BLACKTOWN HOSPITAL REDEVELOPMENT STAGE 2 – RESPONSE TO SUBMISSIONS

The Environmental Impact Statement (EIS) for the Blacktown Hospital Redevelopment Stage 2 (SSD 7058) was publicly exhibited between 5 November 2015 and 4 December 2015.

DRAWING No.	REV
SSD-AR-DG-0132	6

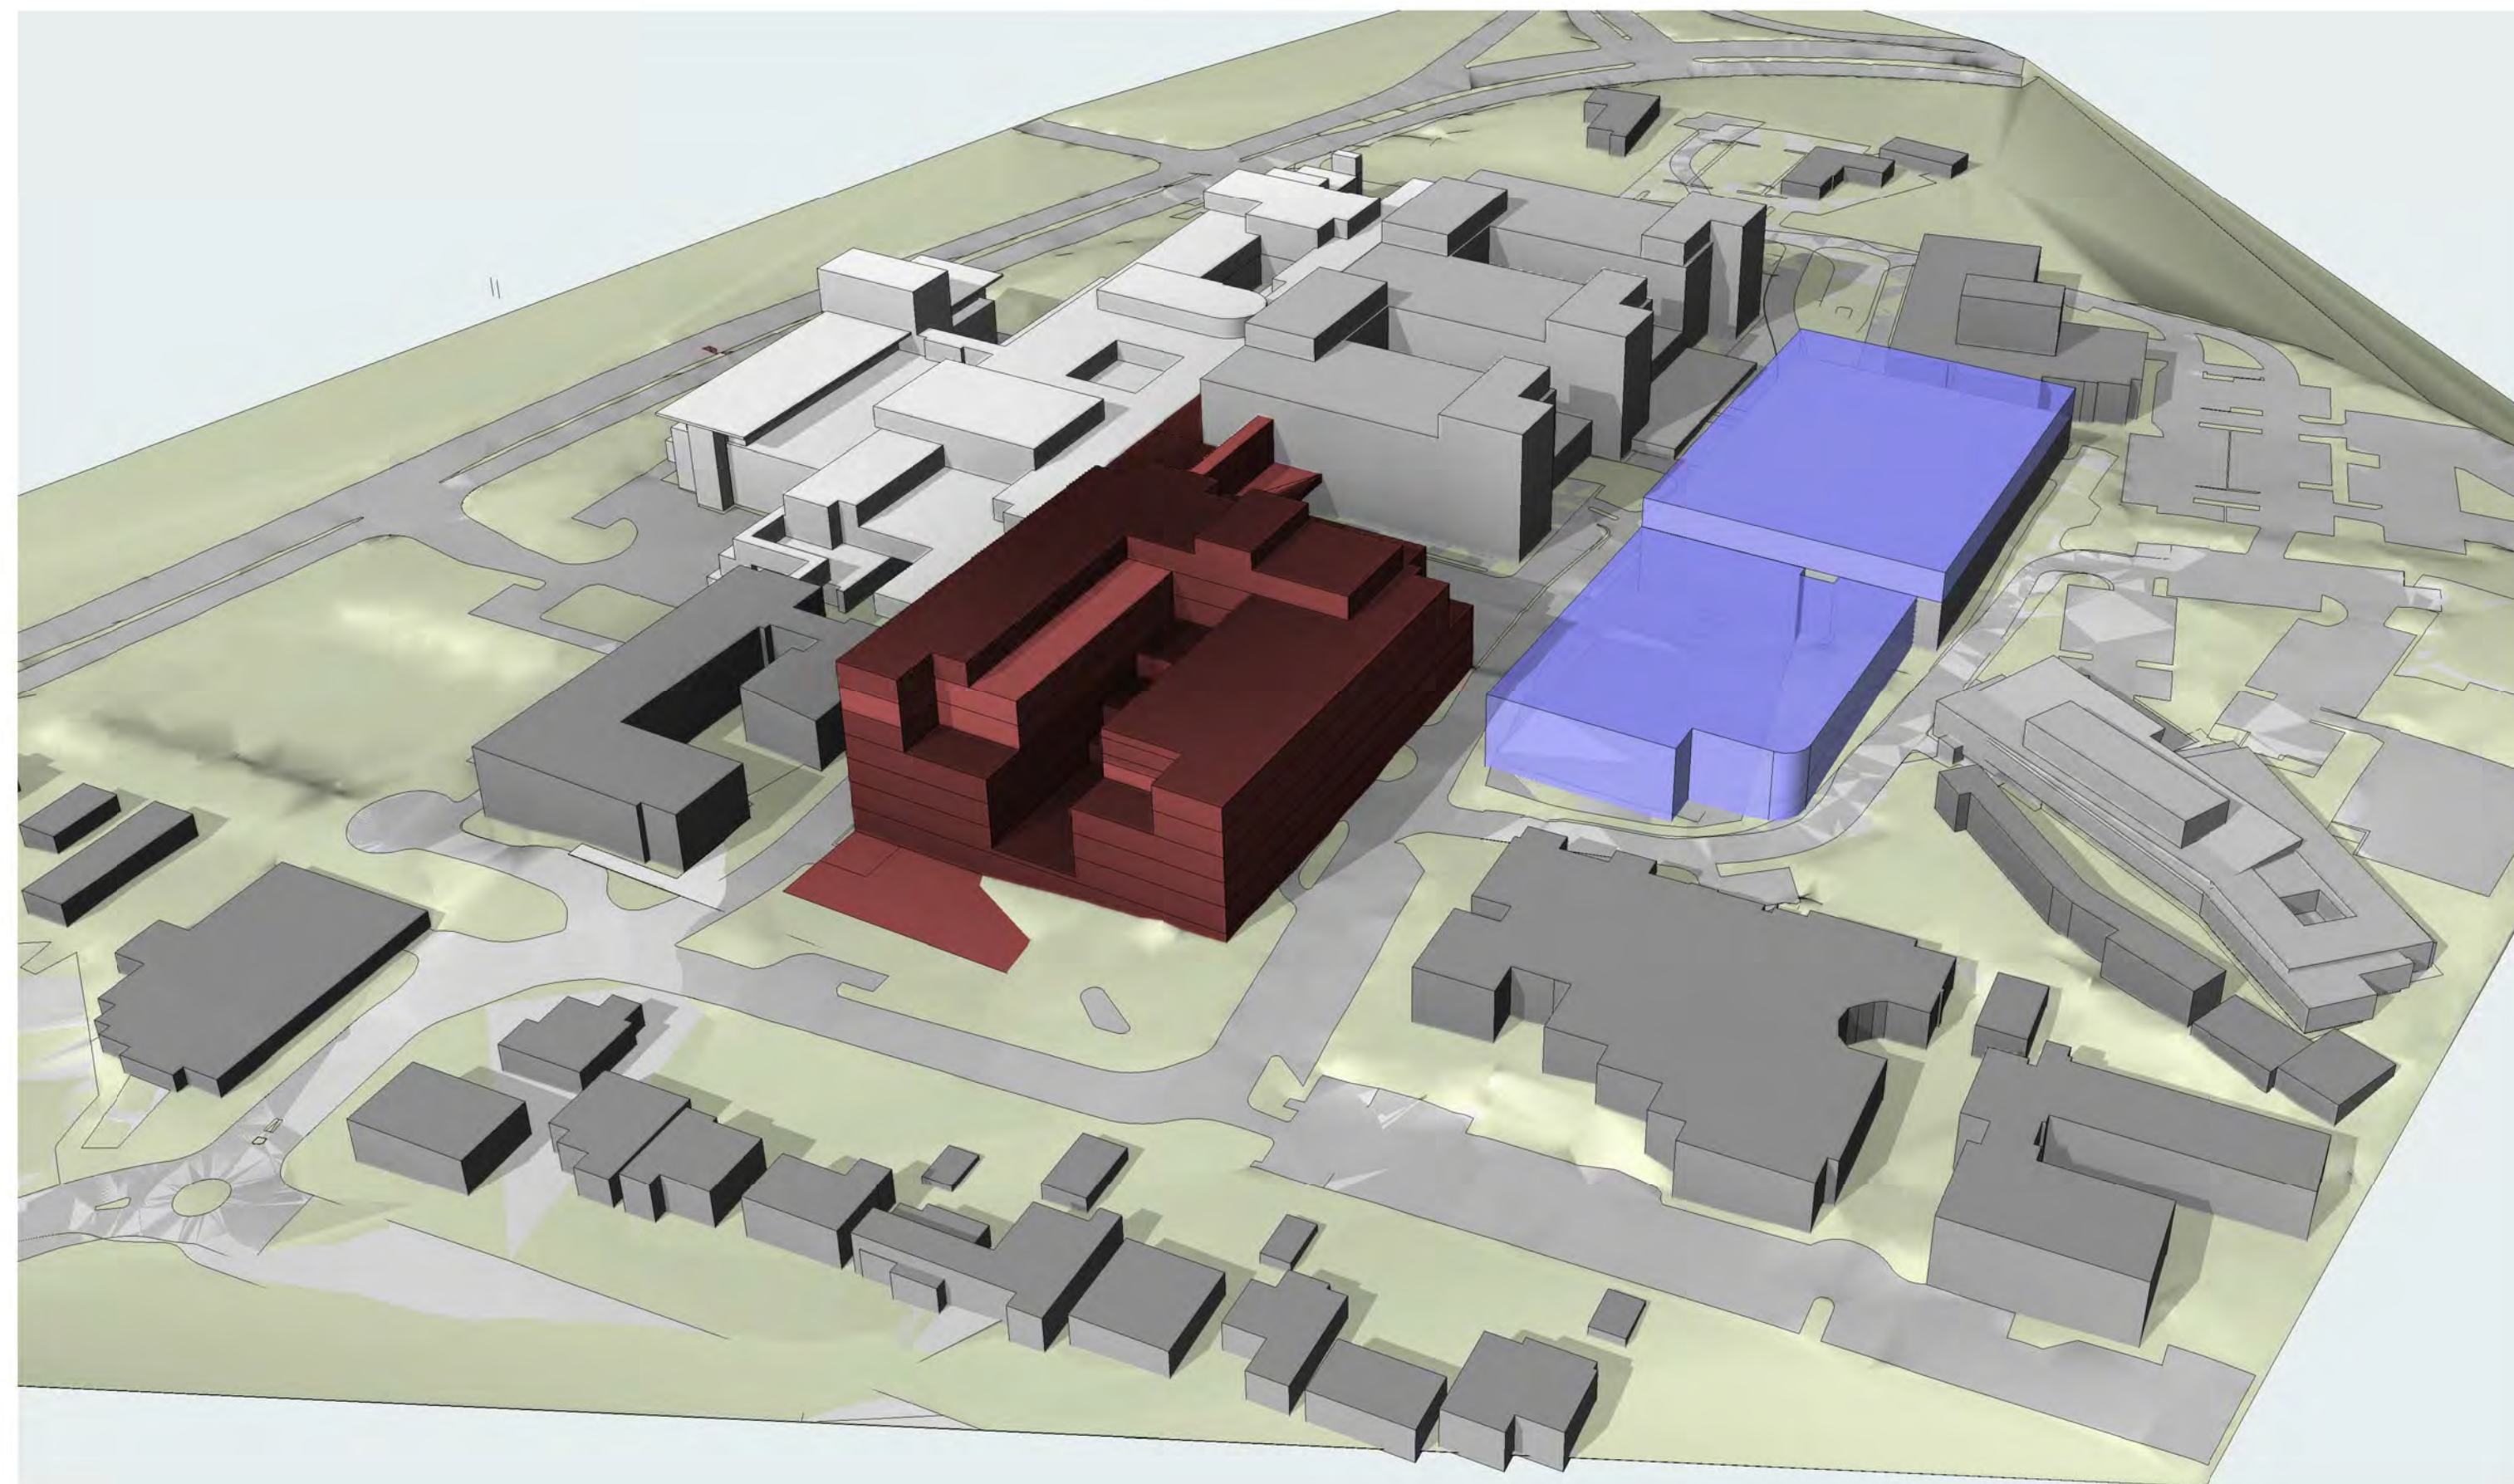
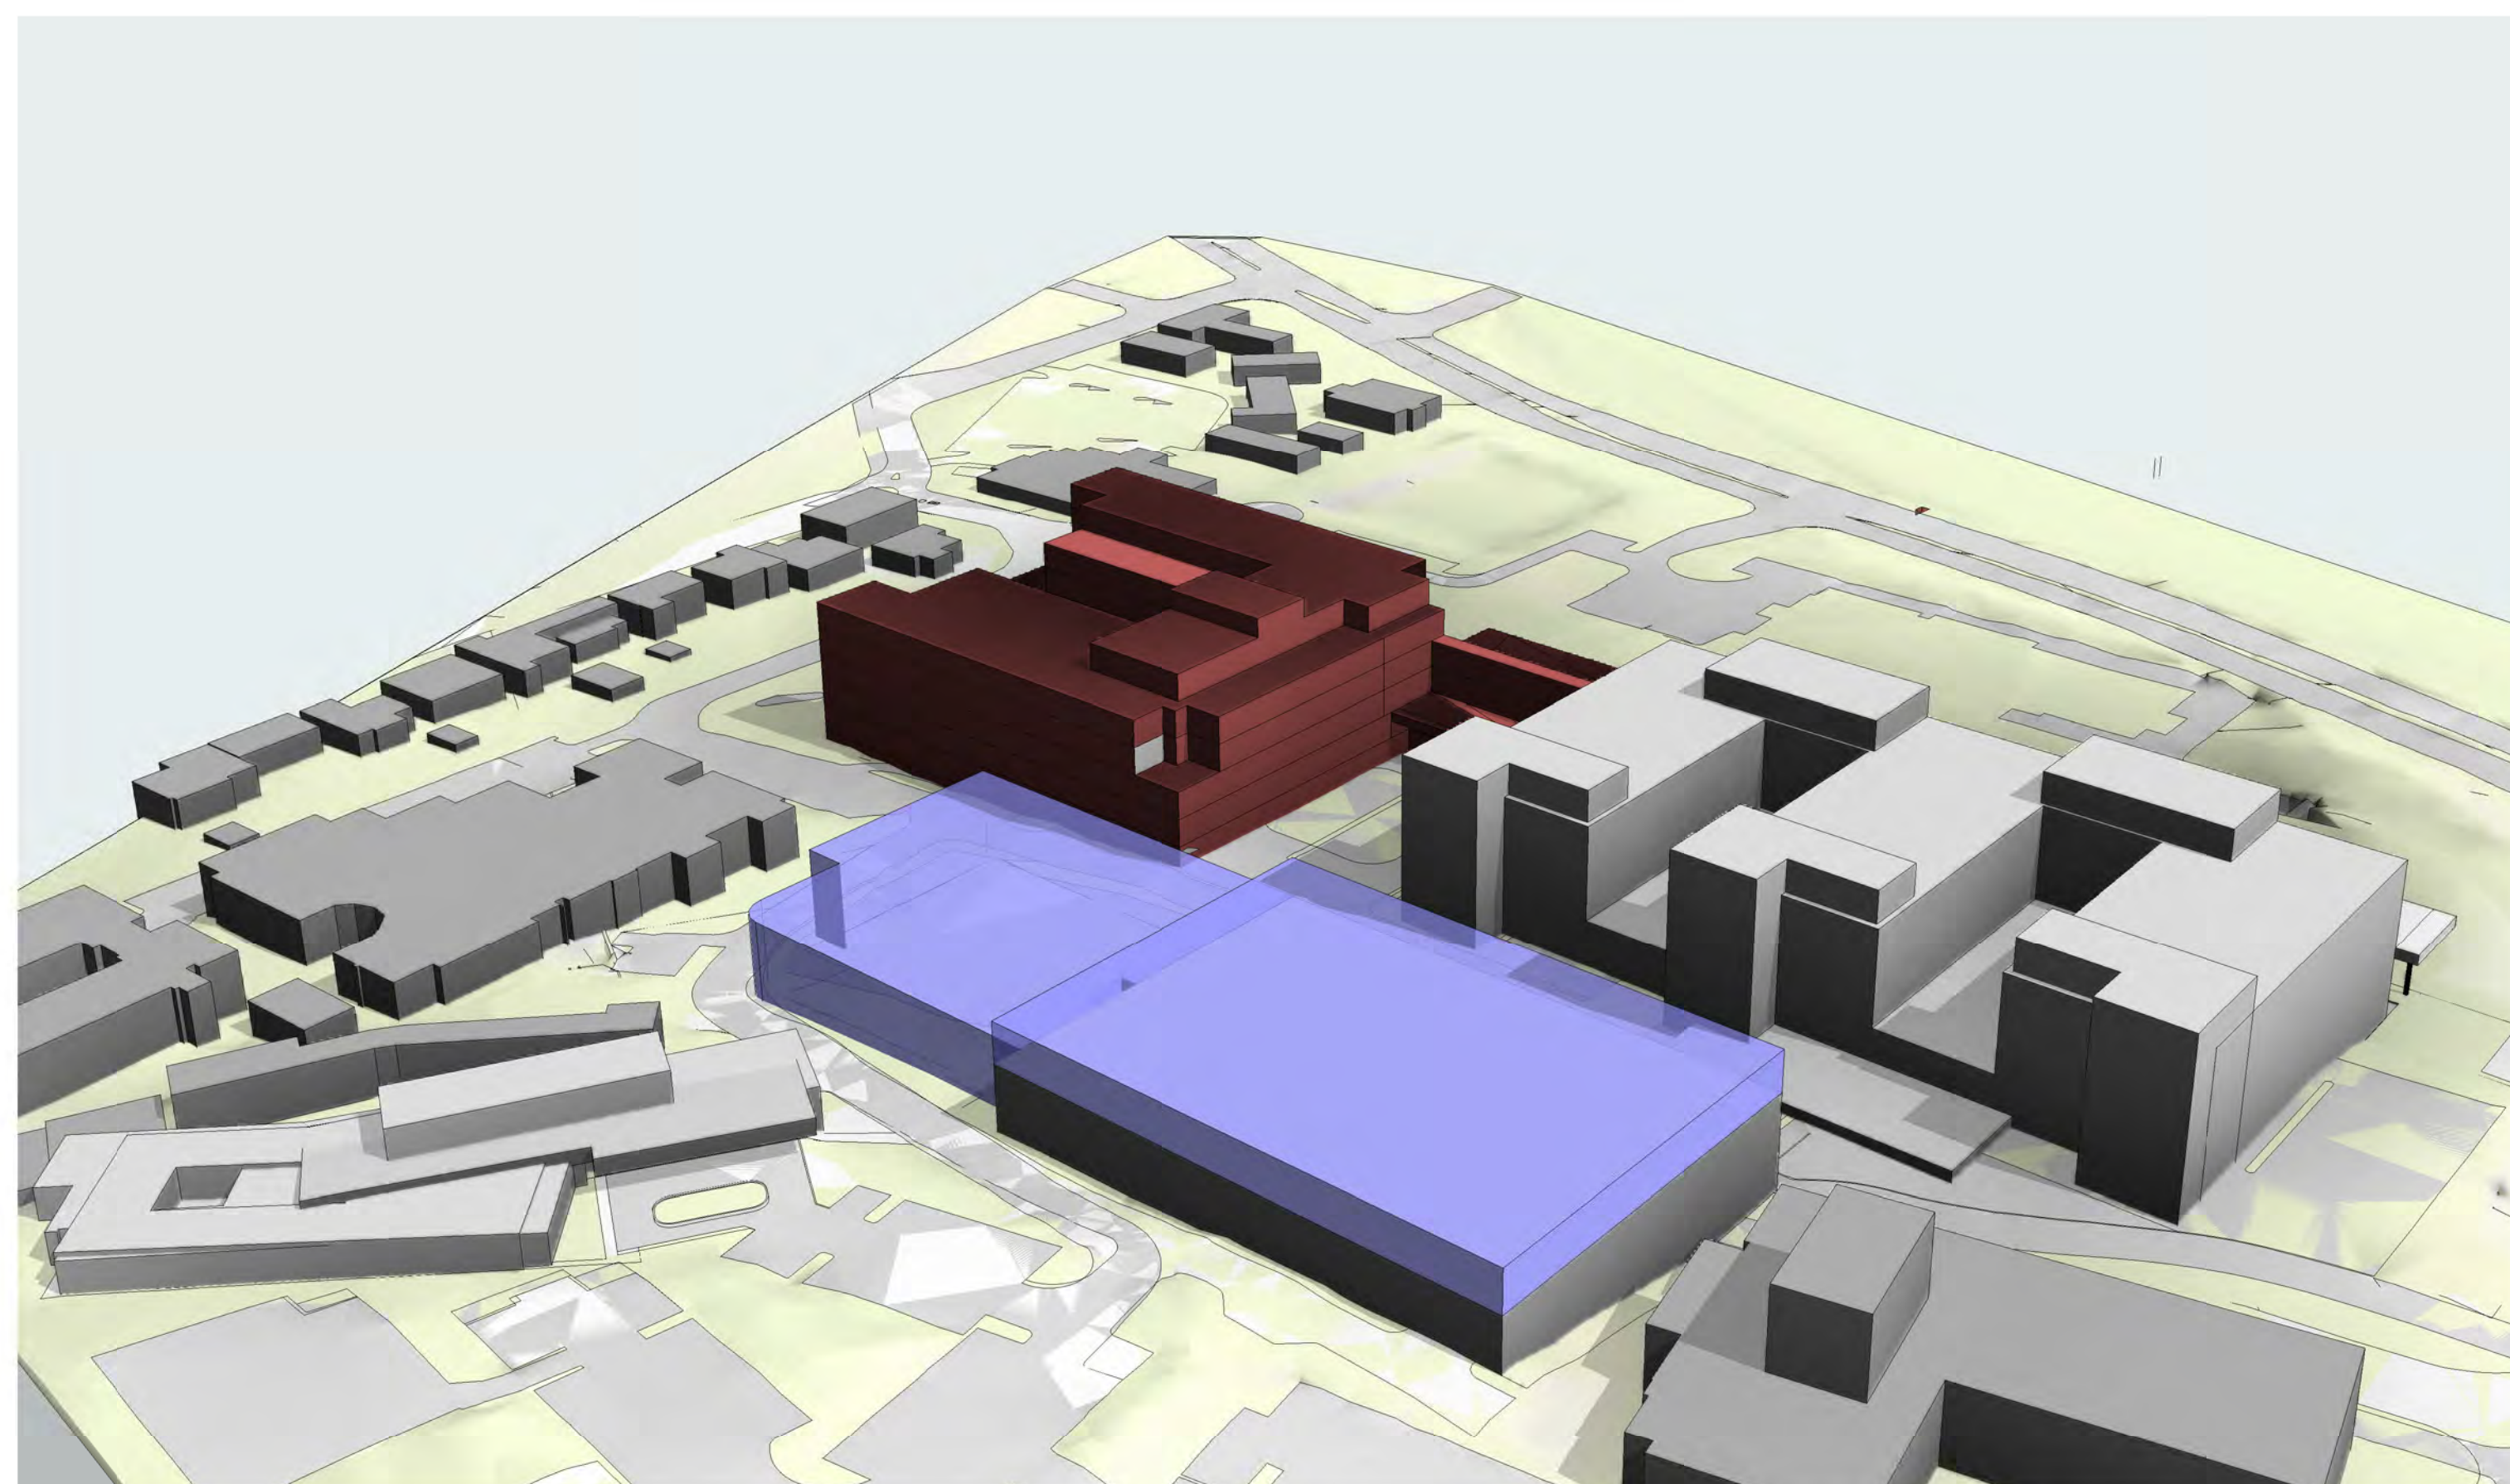
Whilst the building footprint and envelope remain largely unchanged, the height of the building has been reduced. As shown on the updated plans attached, the height of the podium is the same, however the overall height of the building has been reduced to 9 storeys (including plant) from the originally proposed 10 storeys. As demonstrated in the revised shadow and massing diagrams, the changes to the envelope will not result in any additional shadow or view impacts.
